**Washington State
Department of Transportation**

Subject: SP-14-00004 – Boat Ramp
I-90 MP 136.5 Left vicinity

We have reviewed the proposed project. The revised survey of the Boat Ramp Short Plat represents correctly WSDOT property adjacent to Lot 3. We have the following comments.

CRUSE & ASSOCIATES
PROFESSIONAL LAND SURVEYORS
217 E. Fourth St. P.O. Box 959
Ellensburg, WA 98926 (509) 962-8242
BOAT RAMP SHORT PLAT

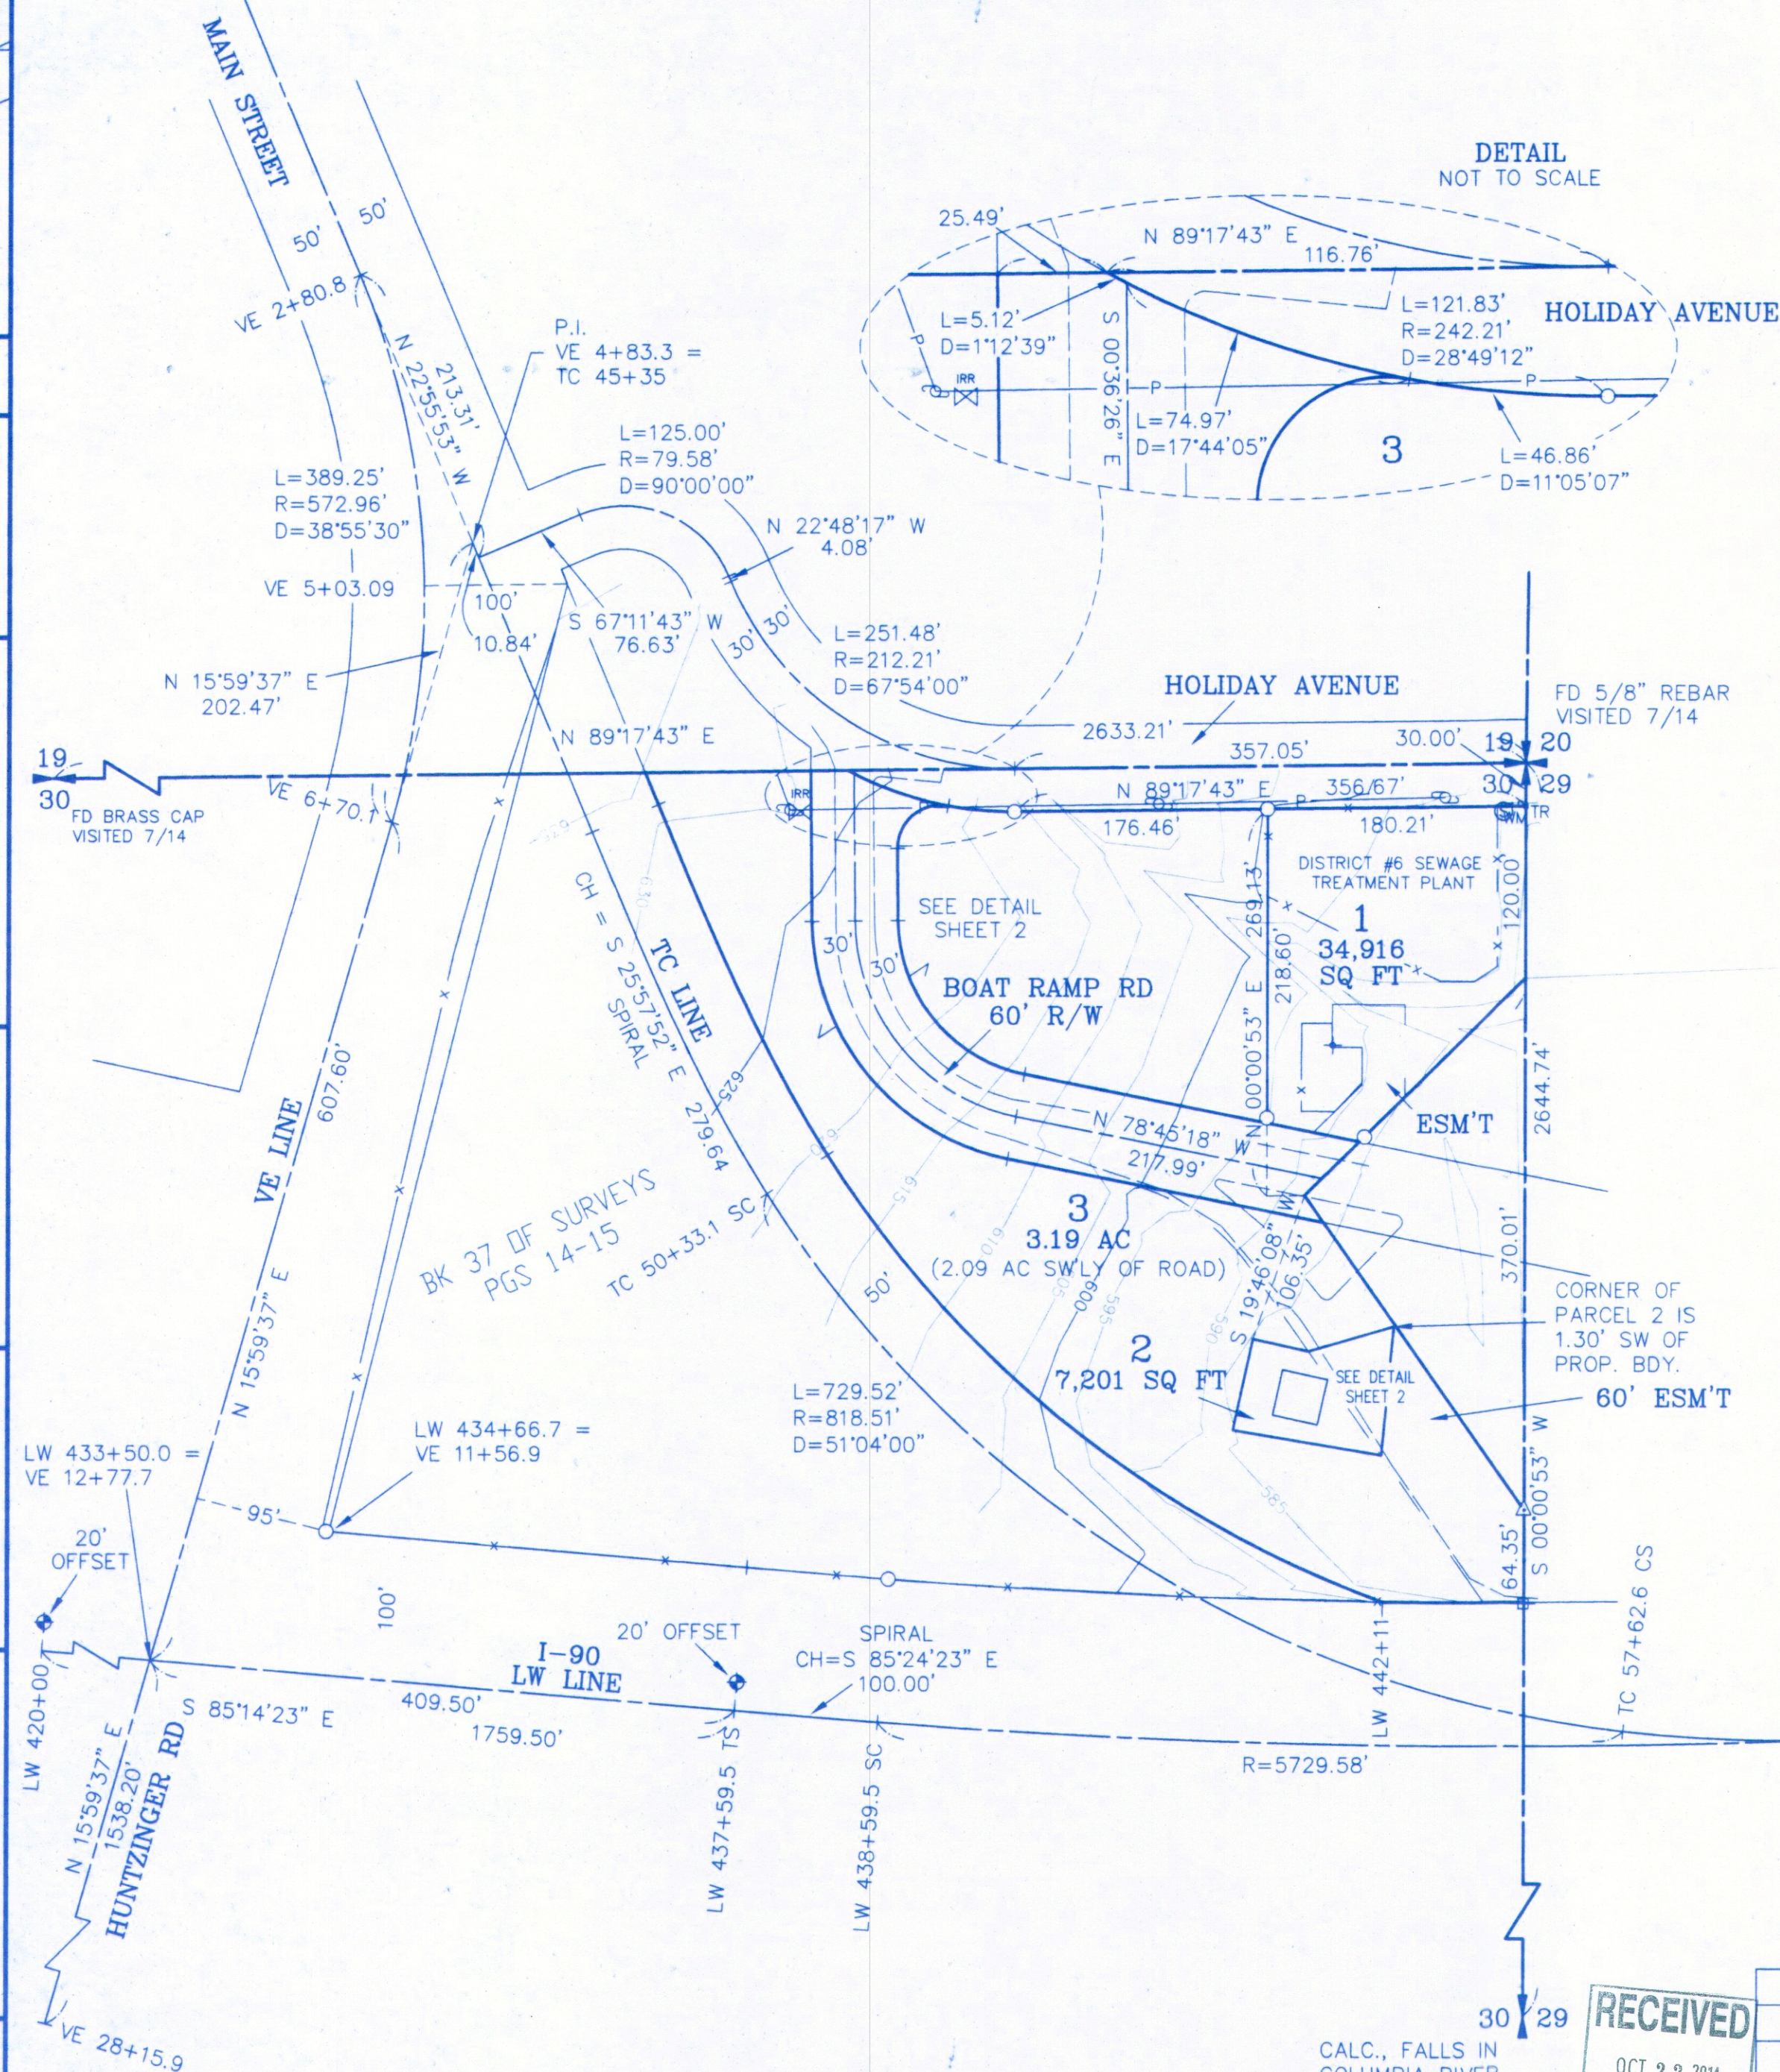
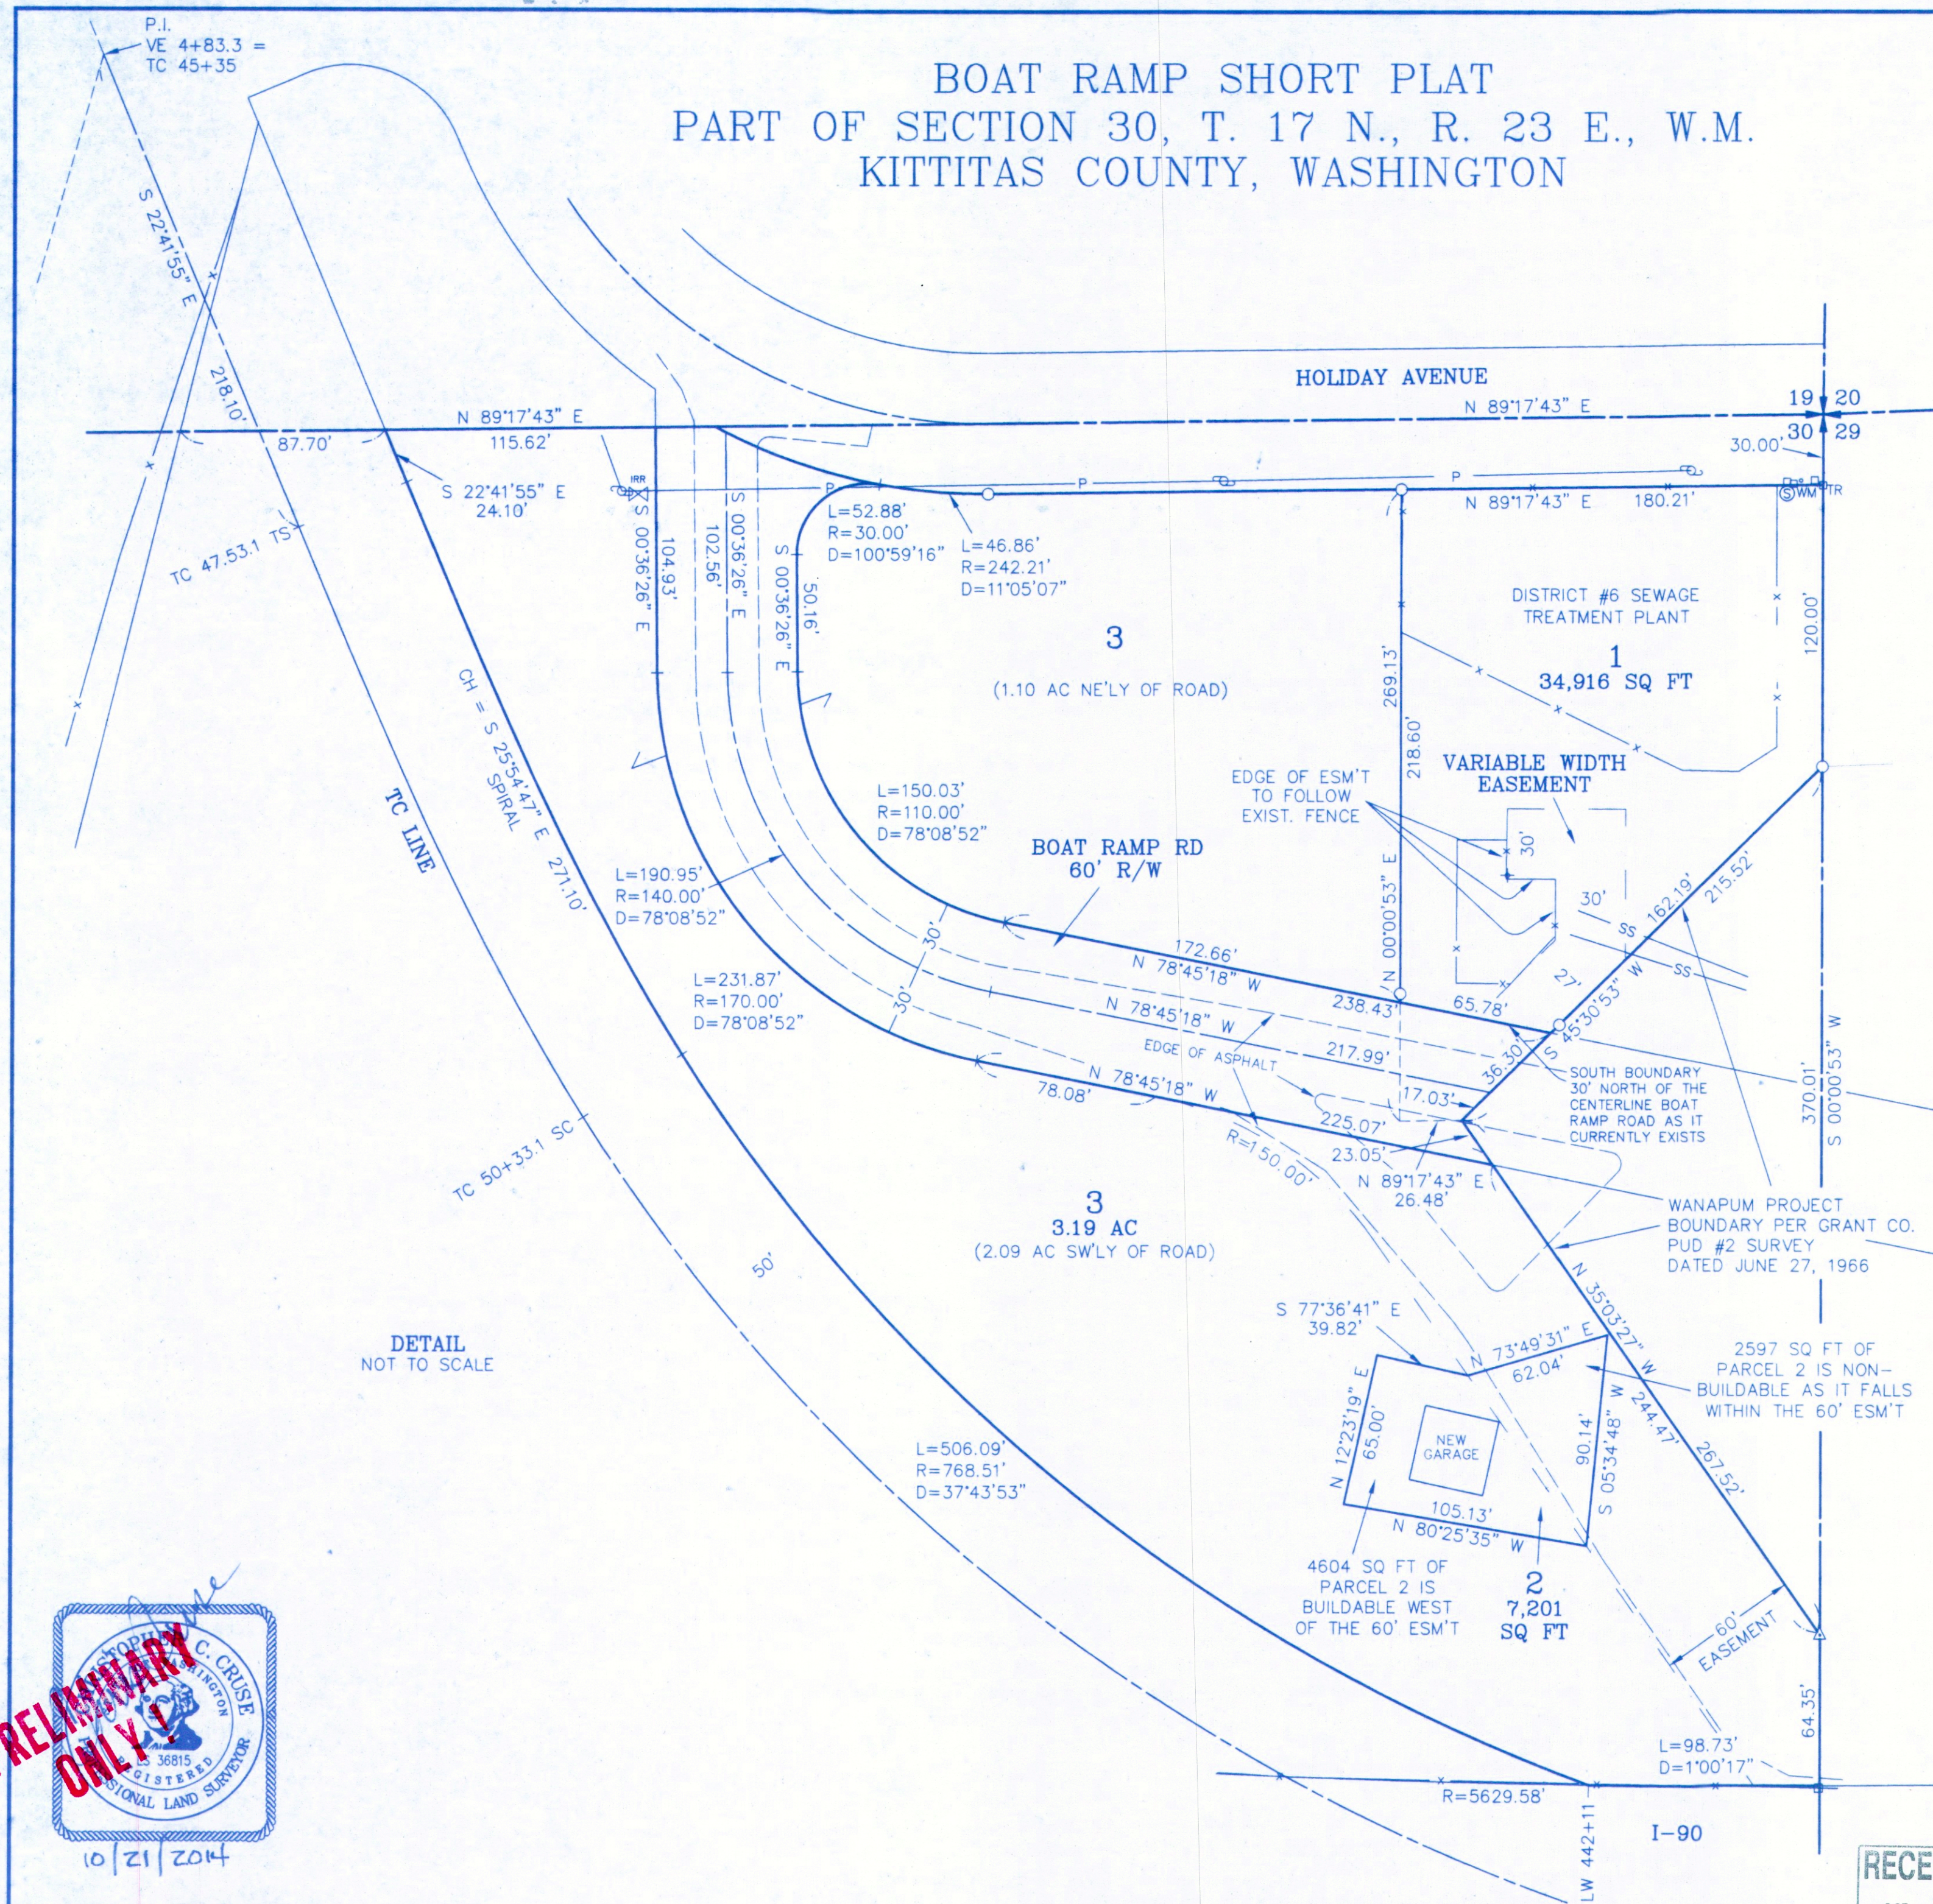
- The proposed project is adjacent to Interstate 90 (I-90). I-90 is a fully-controlled limited access facility with a posted speed limit of 70 miles per hour. No direct access to I-90 will be allowed.
- Stormwater and surface runoff generated by this project must be retained and treated on site, in accordance with regulating agencies' standards, and not allowed to flow onto WSDOT right-of-way.
- Any proposed lighting should be directed down towards the site and away from I-90.
